COMMUNITY SERVICES DEPARTMENT

Subject: Bridle Bit Ranch Filing No.1A (SF-2113)

The Park Operations Division of the Community Services Department has reviewed the Bridle Bit Ranch Filing 1A Minor Subdivision Final Plat and has the following final comments of behalf of El Paso County Parks. This application and the following comments and recommendations were presented to the Park Advisory Board on April 14, 2021.

BRIDLE BIT RANCH FILING NO. 1A

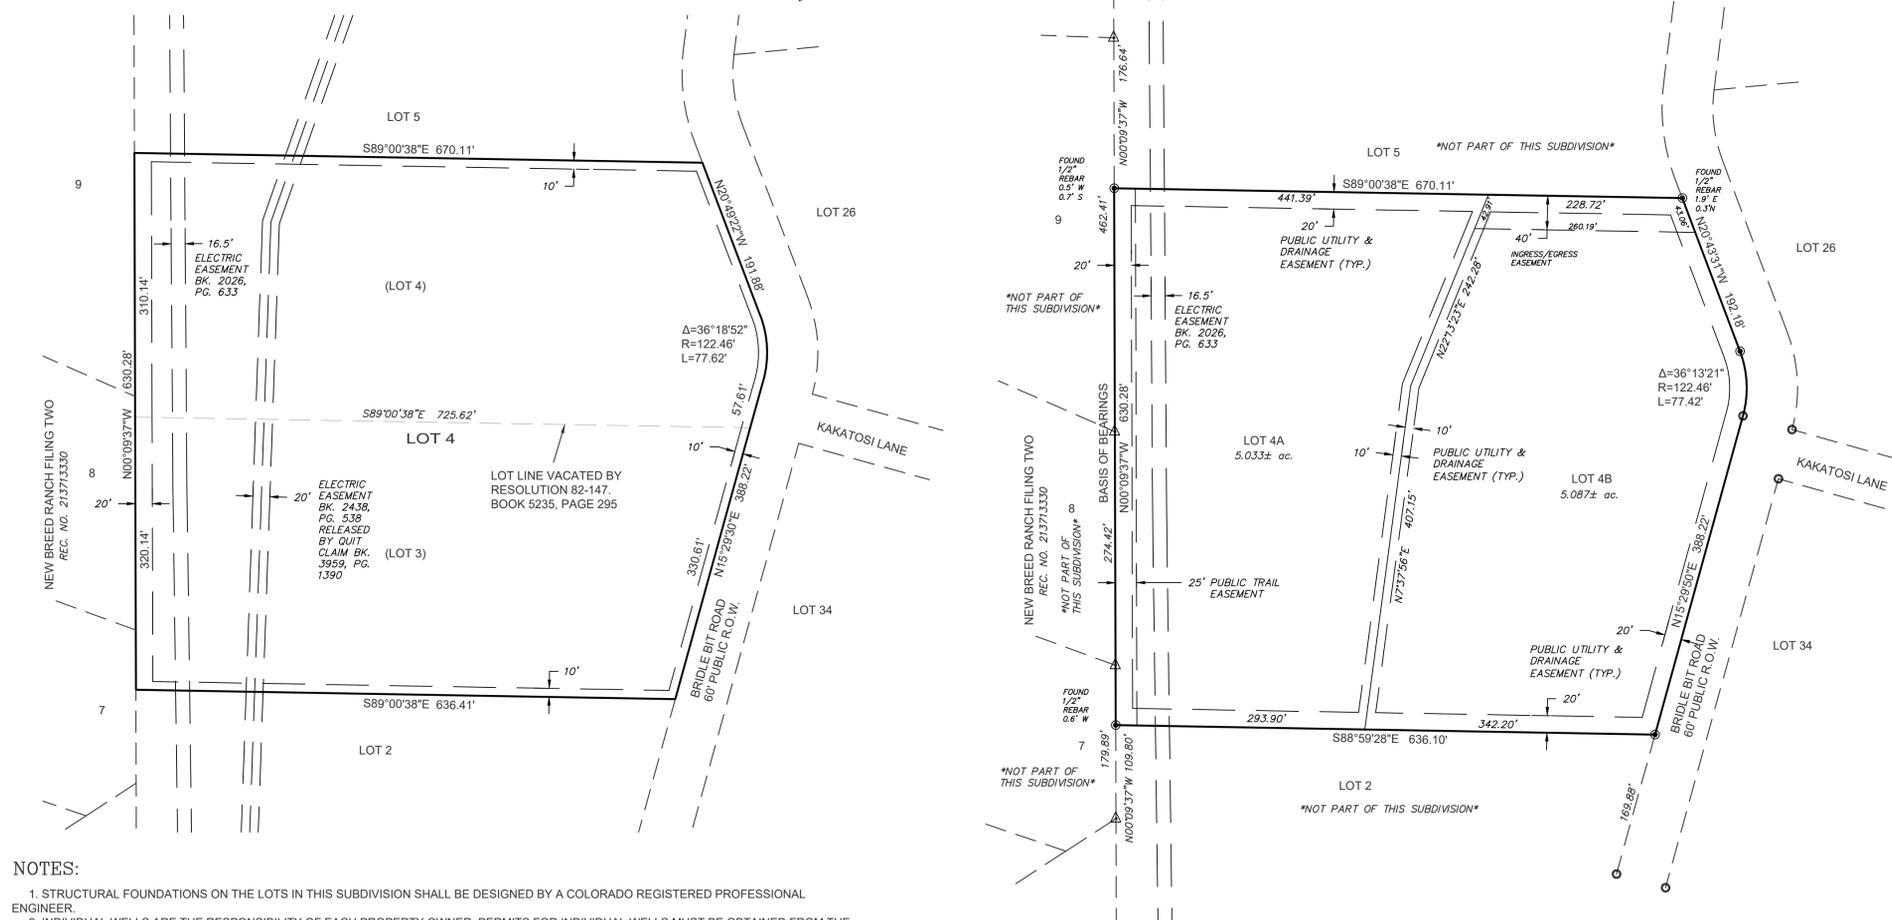
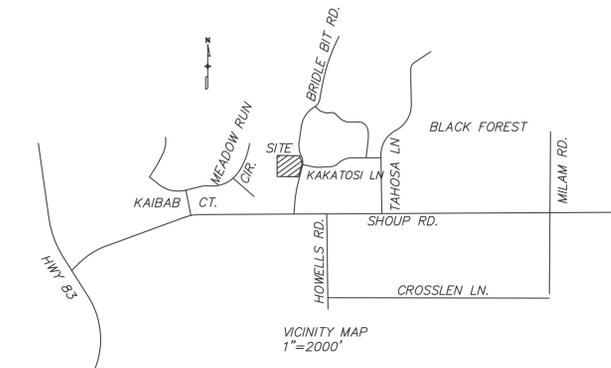
County Parks requests trail easements where development projects impact proposed County trails. As it pertains to this application, the County requests that the landowner provide a 25-foot public trail easement along the western boundary of Bridle Bit Ranch Filing No.1A Final Plat (include date). Since this easement is still not shown the final plat drawings, Staff again asks the easement be shown on the Final Plat Drawing.

The Park Advisory Board recommends to the Planning Commission and Board of County Commissioners when considering and / or approving the Bridle Bit Ranch Filing 1A: (1) Provide to El Paso County a 25-foot trail easement along the western boundary of Bridle Bit Ranch Filing 1A Final Plat that allows for the construction, maintenance, and public access of the LaForet Regional Trail, and dedicate the aforementioned easement to El Paso County prior to the recording of the Final Plat (2) Require fees in lieu of land dedication for regional park purposes in the amount of \$920 which will be required at the time of recording of future final plat(s).
